HOLY CROSS COLLEGE - STAGE 1 ROAD SAFETY AUDIT PREPARED BY BARRY TRANSPORTATION

Clonliffe Lands Development Access Junctions

Stage 1 Road Safety Audit

February 2021

Drawing file: Landscape / L1-915 - DRUMCONDRA ENTRANCE.pdf

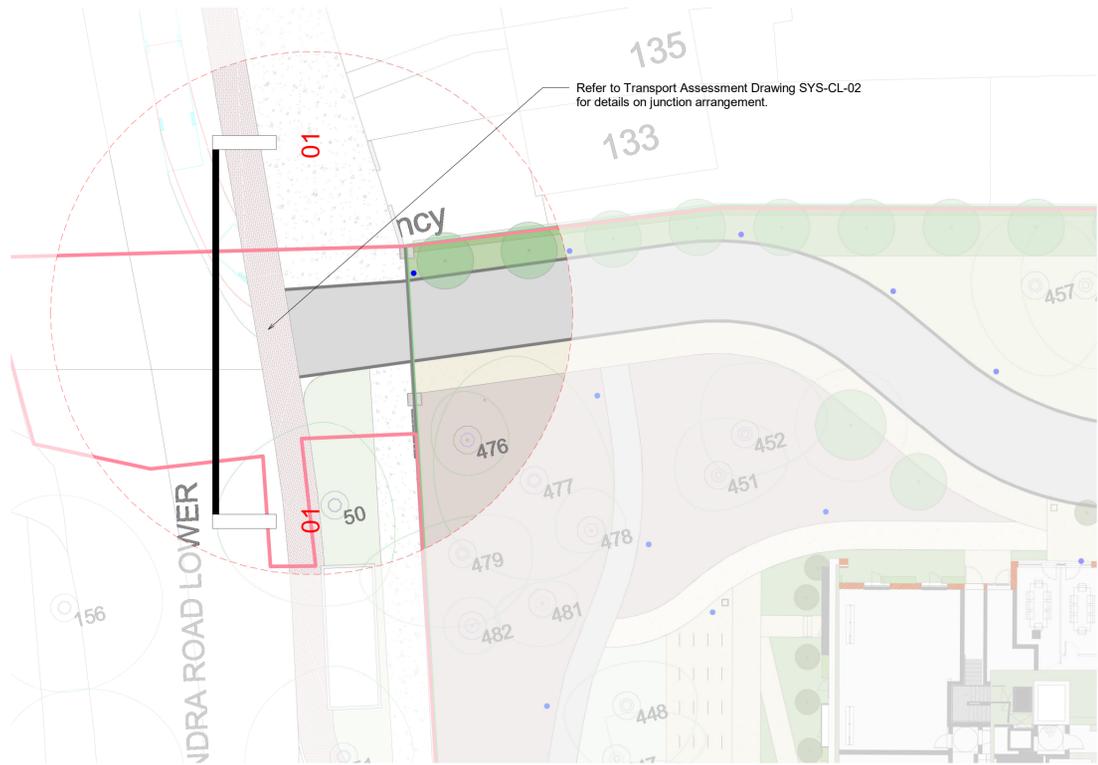
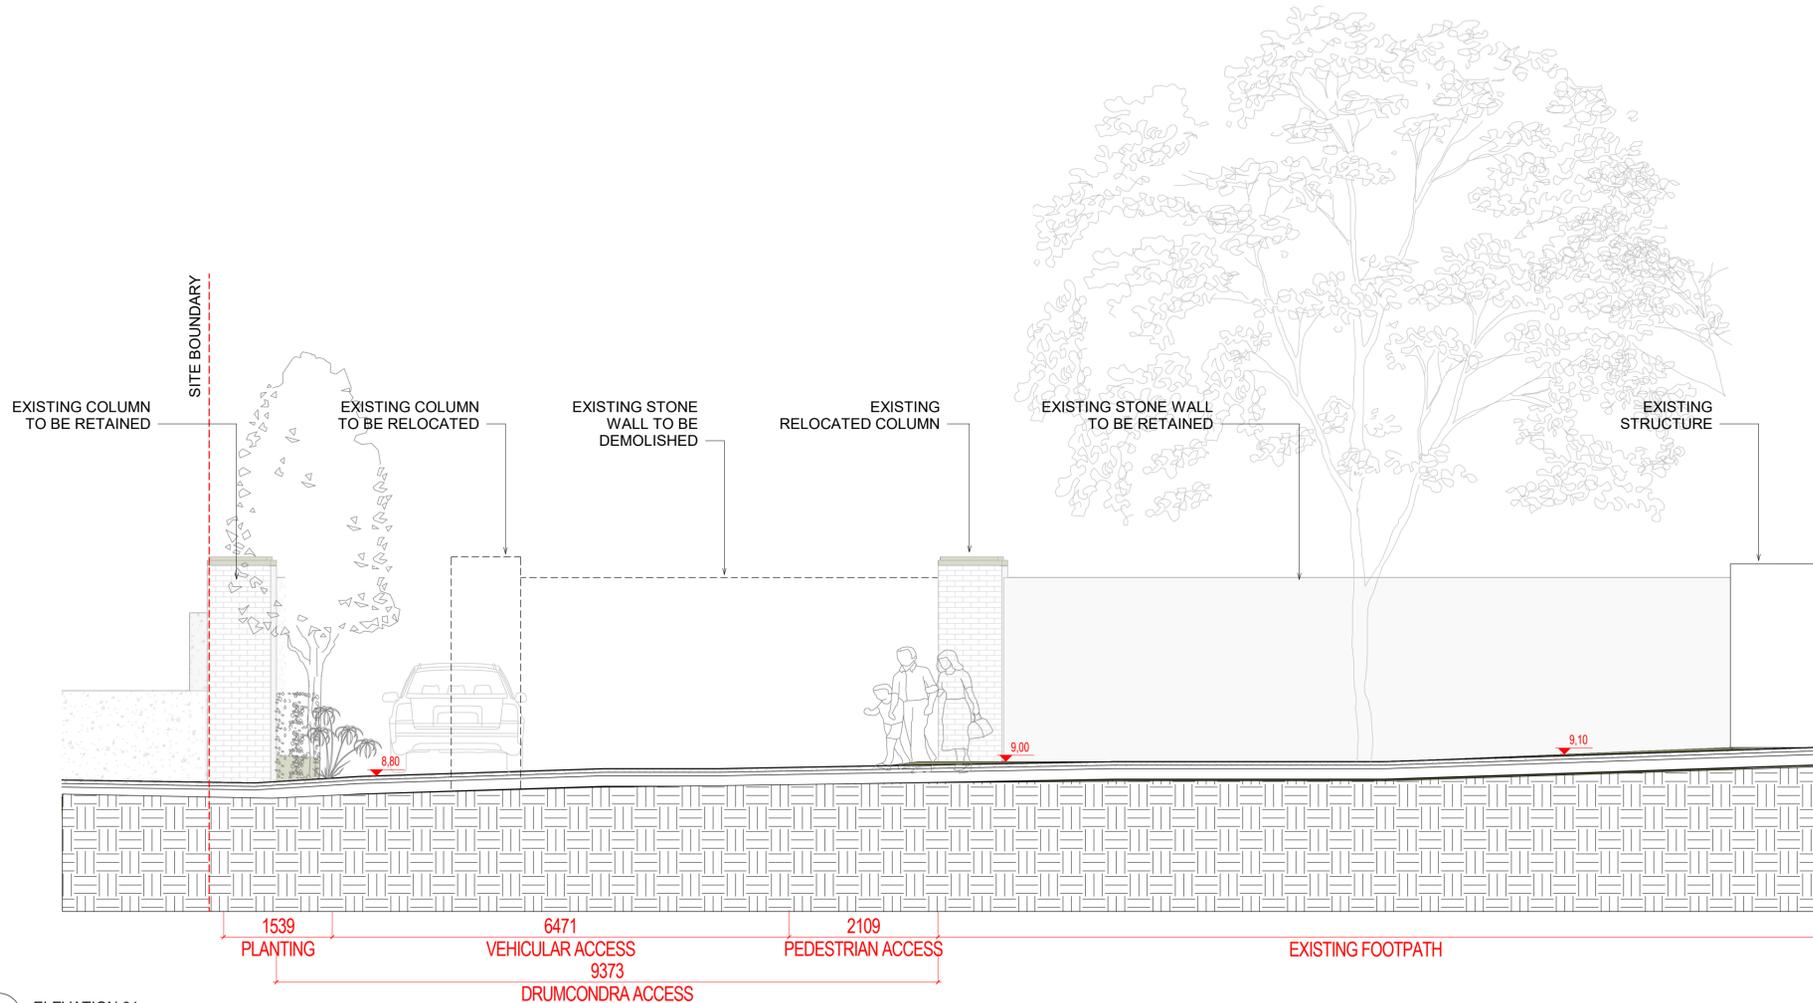
The proposed Left In and Left Out mountable island arrangement at Drumcondra Road does not make it obvious to drivers that they cannot turn right into or out of the development. Furthermore, the deflection island is not a sufficient physical deterrent for these movements. Drivers may disobey (or miss entirely) the signage and turn right in/out of the development or go straight across the junction to and from Hollybank Road with a subsequent high risk of vehicle conflicts.

Provide a larger deflection island, physically forcing vehicles to turn left out of the development, preventing vehicles from turning right or traversing to and from Hollybank Road. Alternatively, provision of a signalised junction would resolve safety issues here.

There will be restricted visibility of the Drumcondra Road Lower footpath due to the boundary walls for drivers exiting the development and this could lead to vehicle/pedestrian collisions. Additionally, there is no traffic calming proposed as part of the access road.

While it is acknowledged that there are restrictions in widening the existing wall opening at the junction to improve visibility, therefore an alternative acceptable solution would be to provide a pedestrian crossing ramp in the form of an entry treatment at the access. This would reinforce pedestrian priority and slow vehicles down. A lower height/slope kerb can be used so that the ramp is gentle and can facilitate a stop line.

Drawing Status: PLANNING
Drawing Number: SYS-CL-01
Rev: C

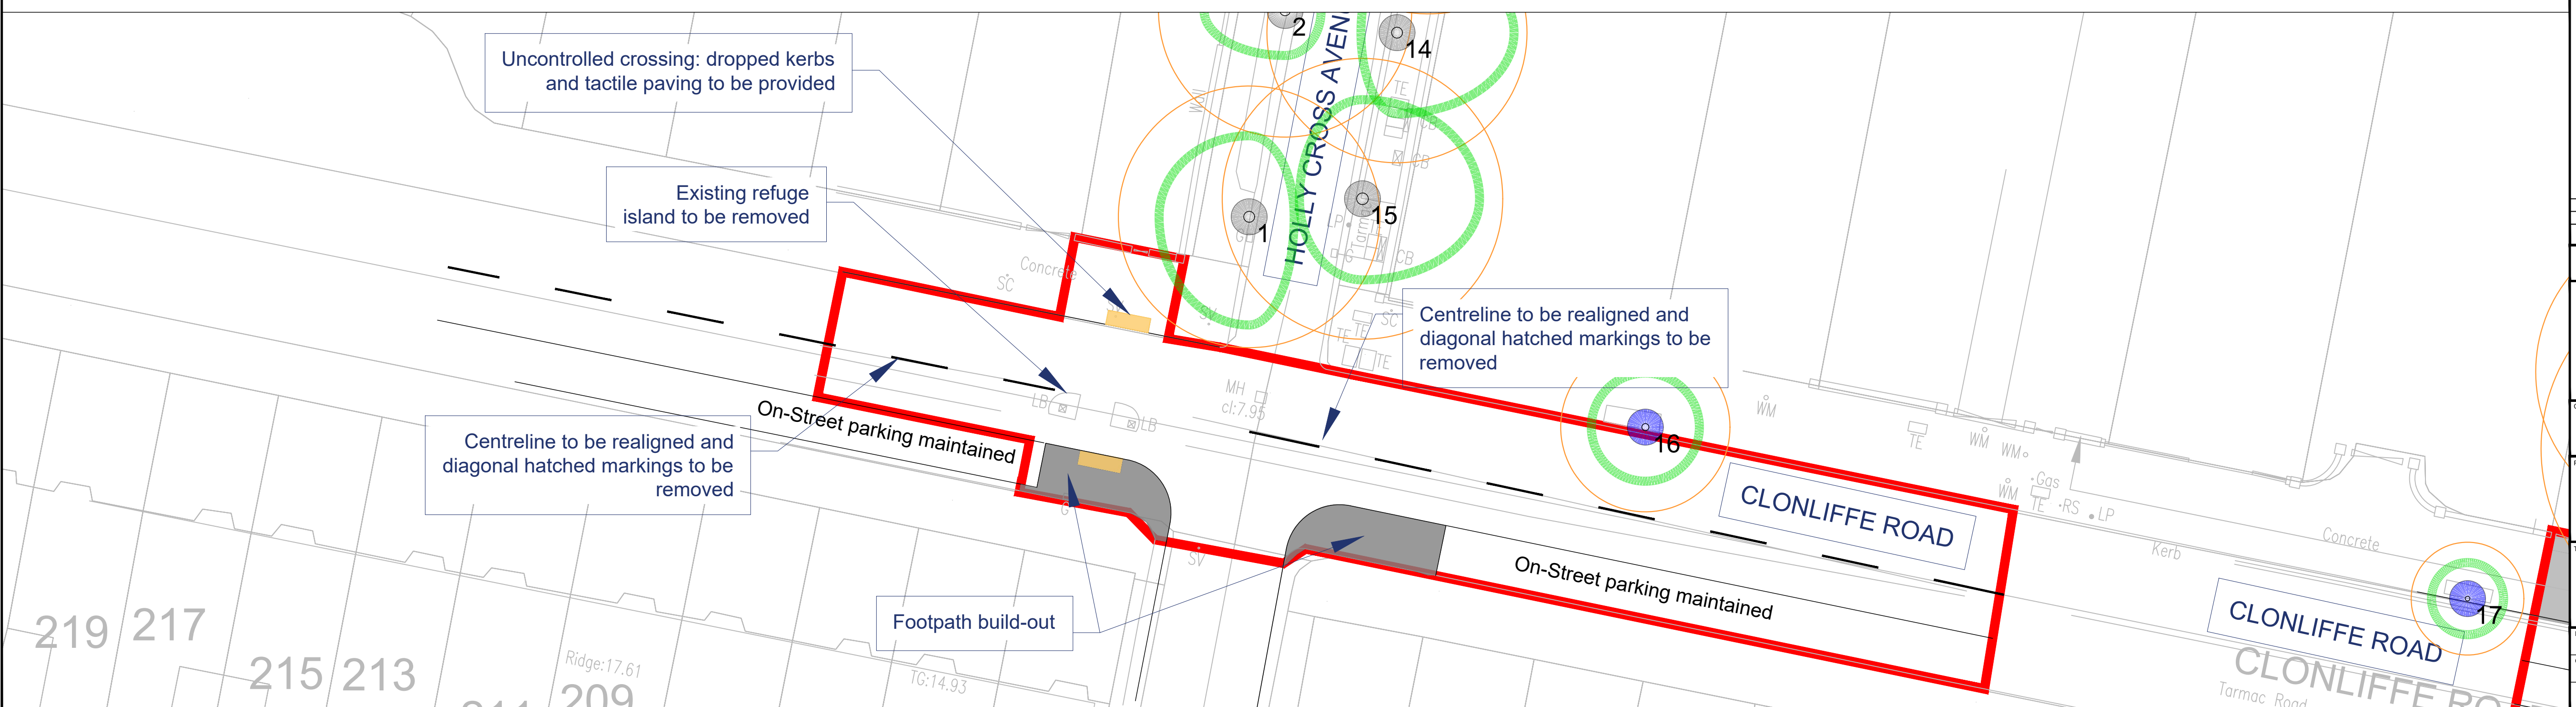
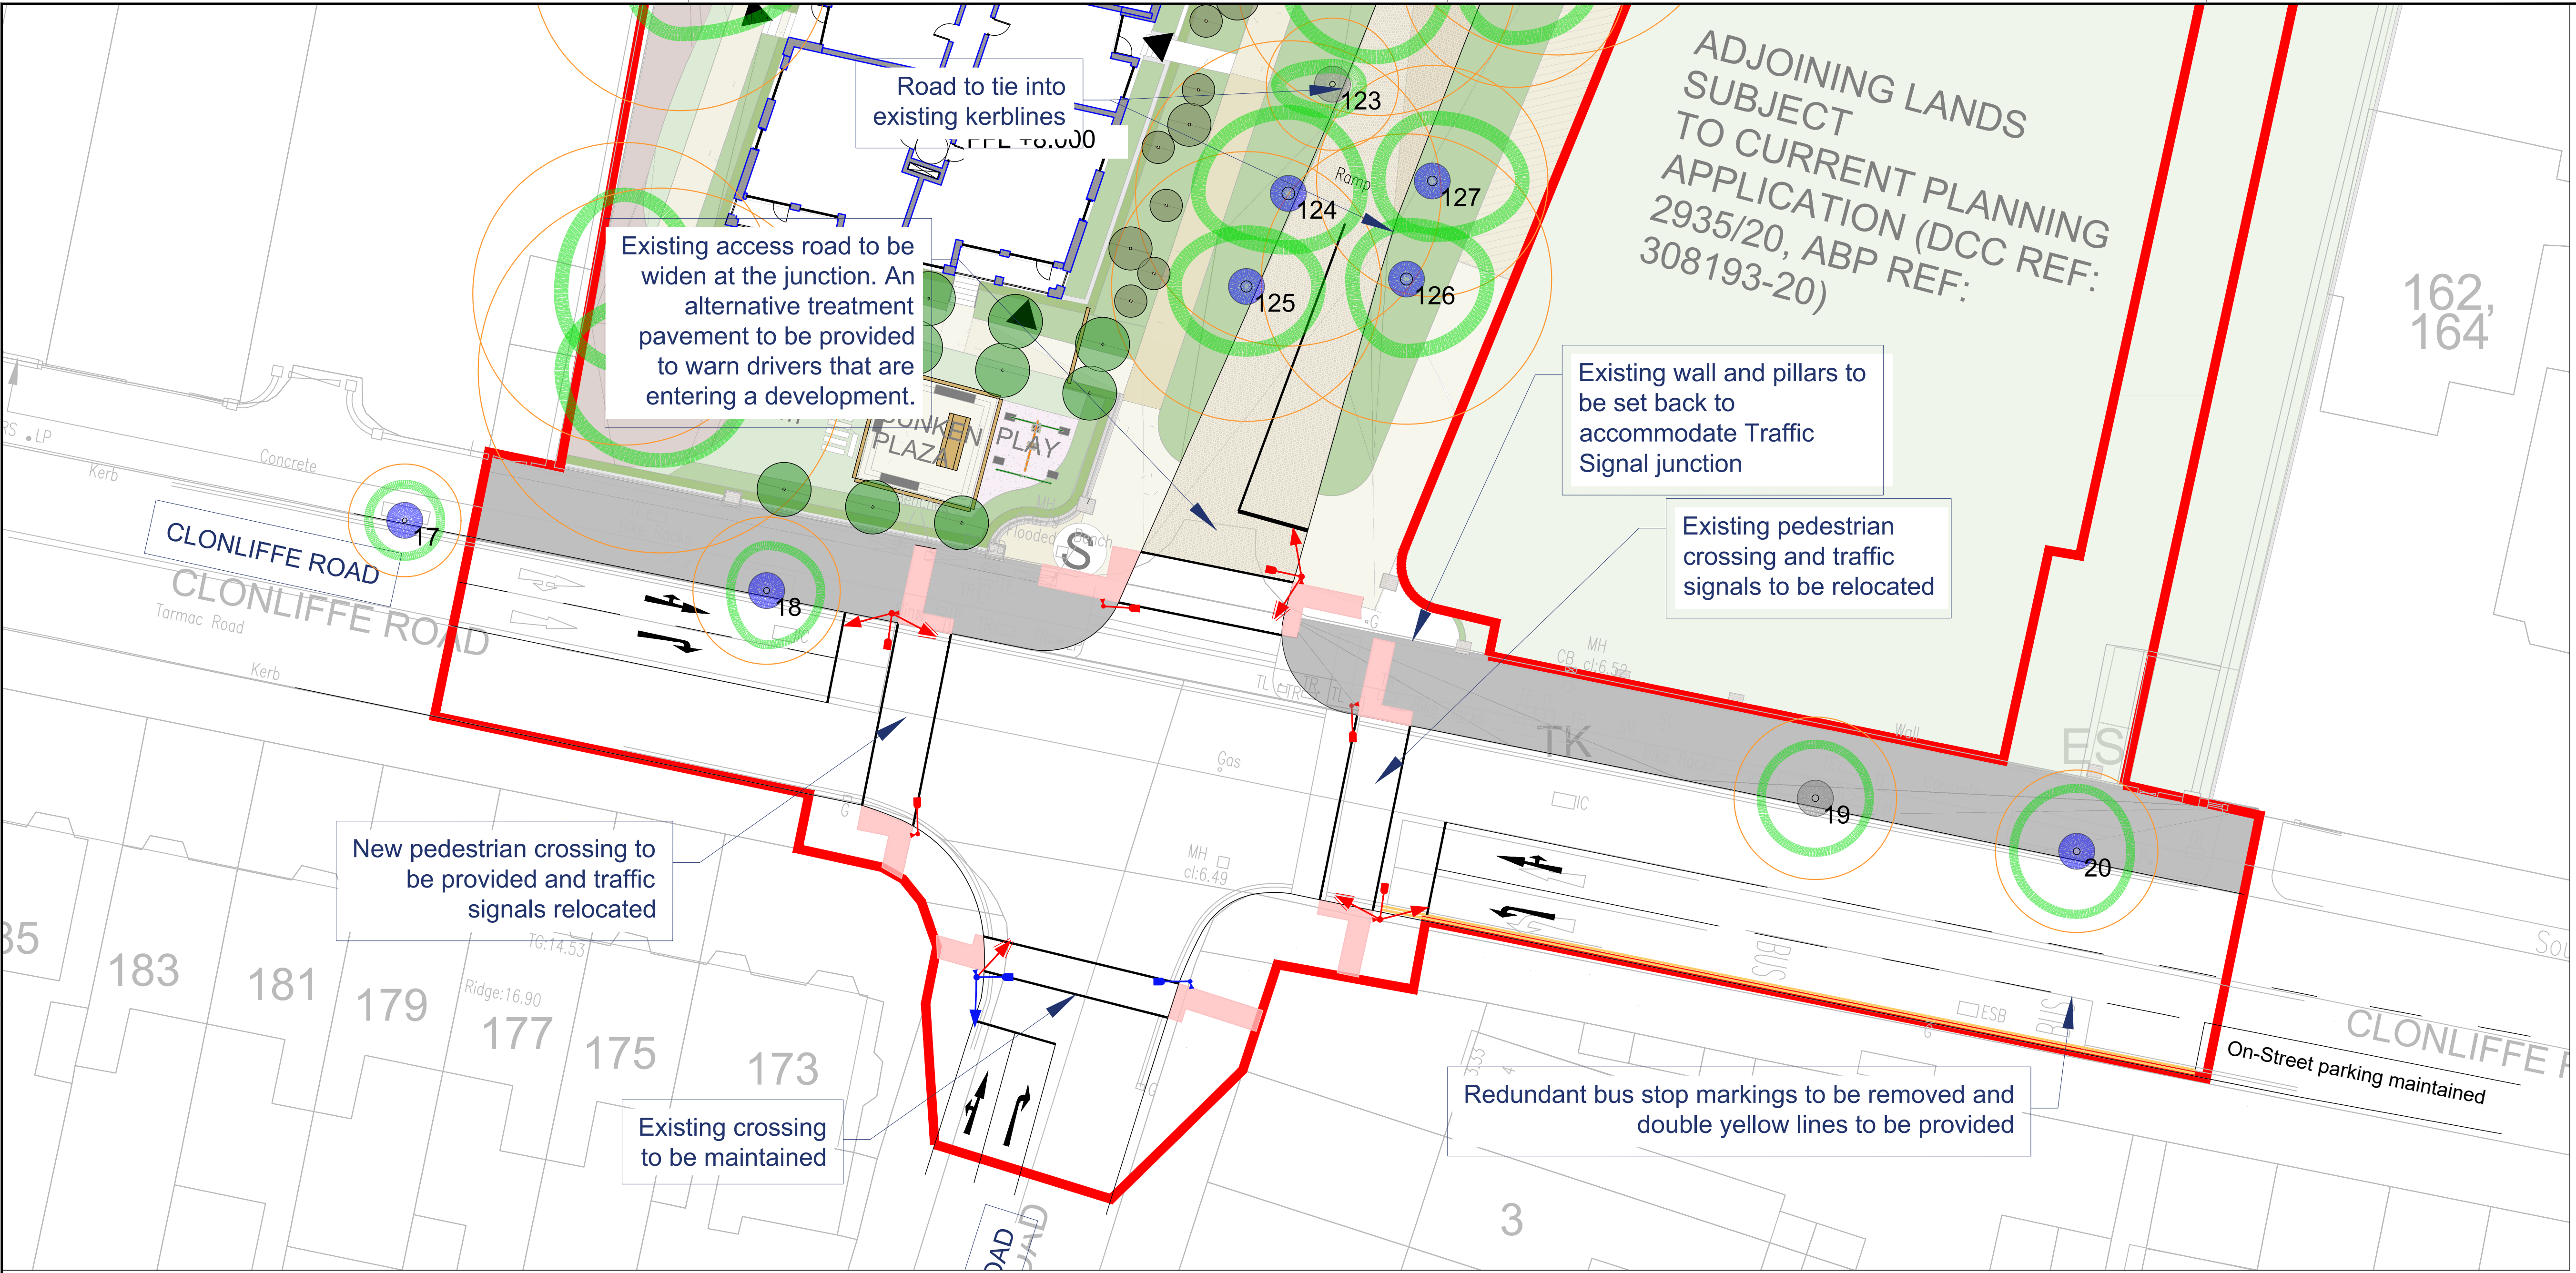
The proposed traffic signals at the Clonliffe Road / Jones' Road junction with the development are inconsistent with the traffic signal arrangement at similar nearby junctions within Dublin City Council. The proposed arrangement includes a primary head, secondary head and a second primary head for each arm. The second primary head is not required at a junction of this nature. See Figure 2.1 of the proposed arrangement and Figure 2.2 for examples of similar junctions near Clonliffe Road with no secondary primary head.

Remove the second primary head at the junction.

The current junction arrangement may give the impression that the Clonliffe Road development entrance is a continuation of the public road from Jones' Road and is not an access to a residential development with no through-traffic permitted, due to the cross-roads nature of the new junction, adoption of traffic signals and the finished proposed for access into the development. This could lead to driver confusion and drivers mistakenly driving straight into the development and then attempting to find a way out again.

Do not provide continuous blacktop road surfacing from Clonliffe Road into the development: provide an alternative colour/texture pavement or a raised table at the entrance to help reinforce that drivers are entering a development and it is not a continuation of the public road.

There is scope for reducing the corner radii at the junction in accordance with DMURS and bringing the pedestrian crossing more in line with the pedestrian desire line

There is an opportunity lost in not creating a more pedestrian and cyclist friendly junction. The presence of left/right turn lanes on all three arms on the public road create a car centred junction. The removal of these lanes, increasing footpath widths, providing buildouts, and reducing the corner radii would be a far better safer environment for cyclists and pedestrians.

Transverse road markings at the uncontrolled pedestrian crossing should be omitted in accordance with normal practice.

Paragraph No. in Report	To Be Completed by the Design Team			To Be Completed by the Audit Team
	Problem accepted (yes/no)	Recommended measure accepted (yes/no)	Designer's Response / Alternative measures (describe)	Designer's Response / Alternative Measures accepted by Auditors (yes/no)
2.1	Yes	Yes	Secondary primary heads have been removed, as shown on the revised junction arrangement drawing	Yes
2.2	Yes	Yes	An alternative colour/texture pavement is proposed to be provided at the road access entrance, as shown on the revised junction arrangement drawing	Yes
3.1	Yes	Yes	A larger deflection island is proposed to be provided, as shown on the revised junction arrangement drawing	Yes
3.2	Yes	Yes	Entry treatment incorporating raised area of contrasting material is proposed to be provided, as shown on the revised junction arrangement drawing	Yes
